**Consultation Response from KC,
Highways Development Management****2025/93394 Rowley Mills, Penistone Road, Fenay Bridge, Huddersfield, HD8 0LE****Erection of 3 storey front extension and 2 storey rear extension of Rowley Mills with associated car park amendments, ancillary structures and landscaping; first floor roof extensions, car park amendments and landscaping at International House with new access infrastructure and pedestrian crossing facility****Date Responded:** 16th June 2026**Responding Officer:** C Dows**Responding Ref:** K11-11/2**Recommendation:**

Subject to addressing minor access issues, as detailed in the main body of the report, undertaking a Stage 1 RSA and providing a Designer's Response, which satisfactorily addresses any issues raised, HDM have no objection to the proposals.

STATUS: - REVISION: G

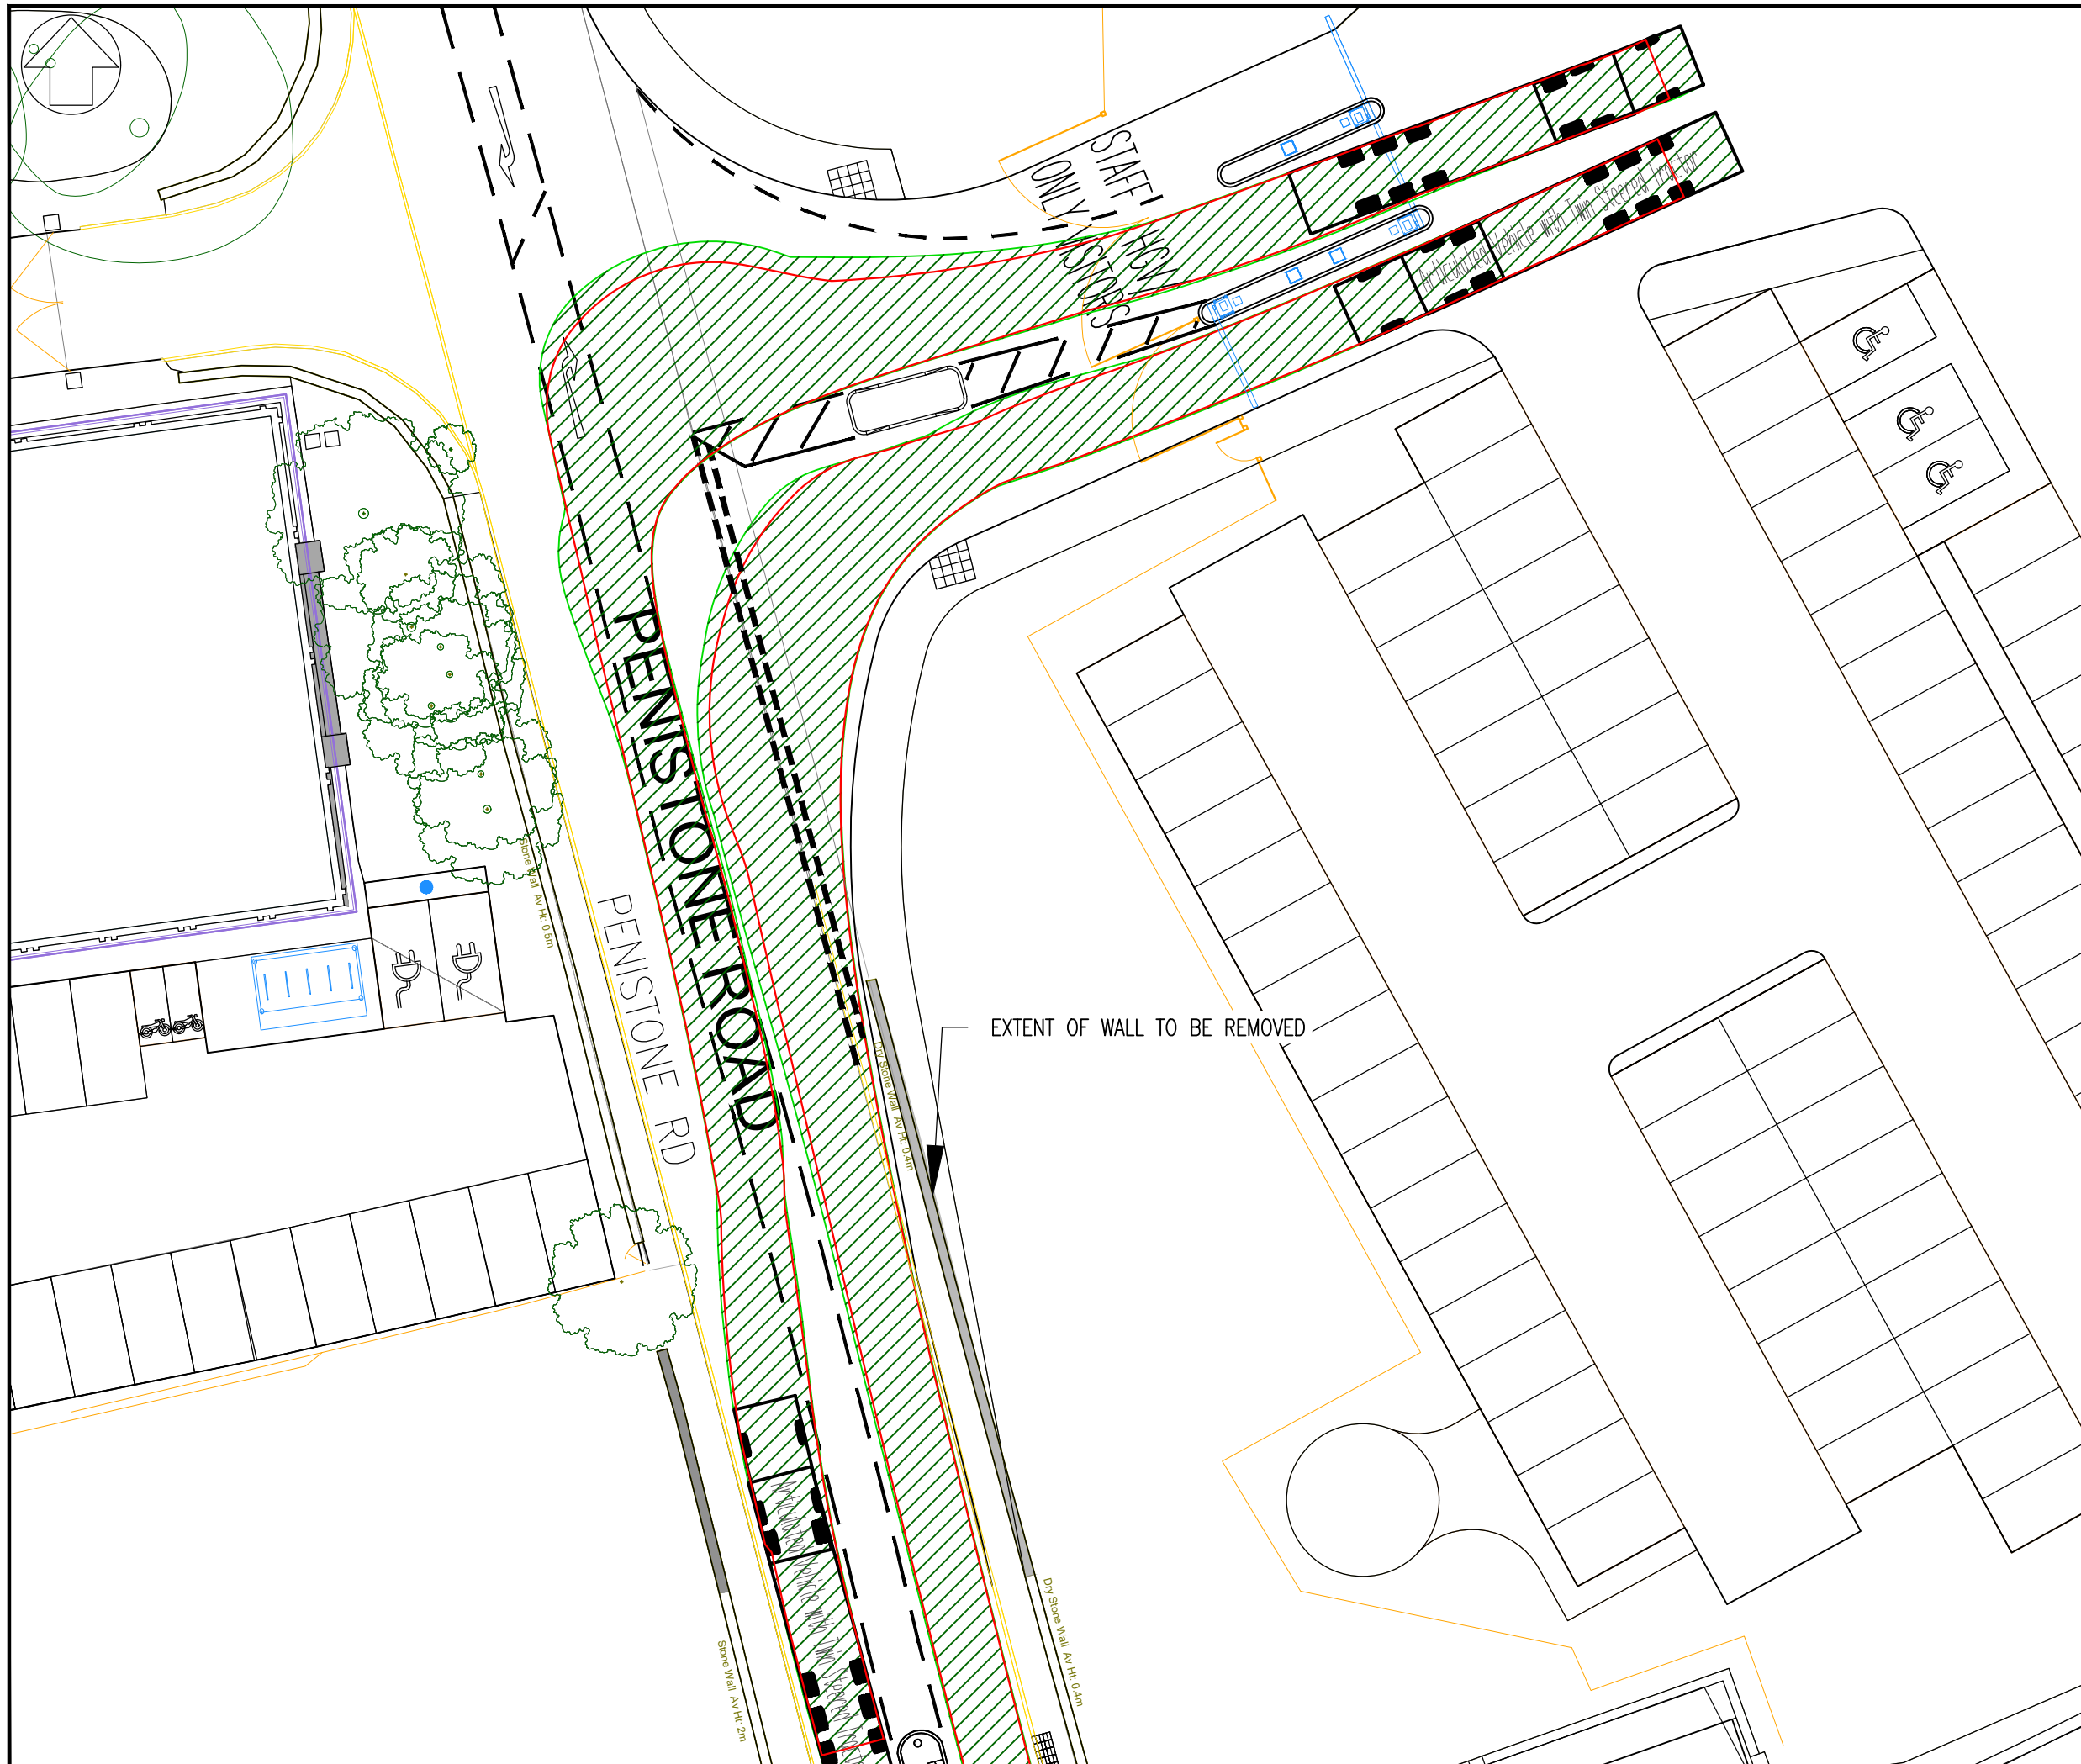
- Drawing No. 2310005 Rev. G – Proposed Pedestrian Crossing Island, should be amended to incorporate the dimensions (blue) and markings (red) shown on the extract below, which was provided following pre-application discussions.
- The island should also be dimensioned. The island should be wide enough to safely shelter pedestrians, but not so wide that lane widths are overly physically restricted, and/or there is inadequate clearance between the edges of the island and the lane marking. Given the overall cross-sectional dimension of 8.6m it is considered an island width of 1.8m should be adequate.

REV	DATE	BY	DESCRIPTION	APP
P03	19/11/2025	HT	ISLAND AMENDED	EG
P02	29/10/2025	HT	GENERAL AMENDMENTS	CY
P01	17/10/2025	LC	FIRST ISSUE	CY

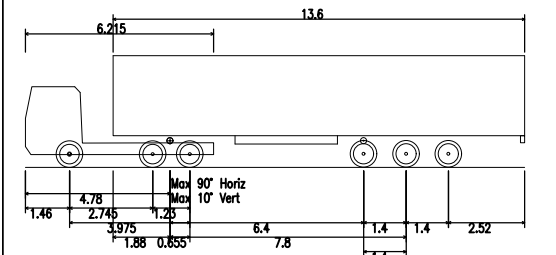
- Drawing No.2310010 Rev. P03 – Vehicle Swept Paths (extract below), the curved alignment of the lining demarcating the staff only and HGV lanes appears misleading guiding vehicles towards the HGV lane. Suggest the curved length of line markings are removed retaining a shorter straight section of demarcation with the introduction arrows directing vehicles to the appropriate lane.
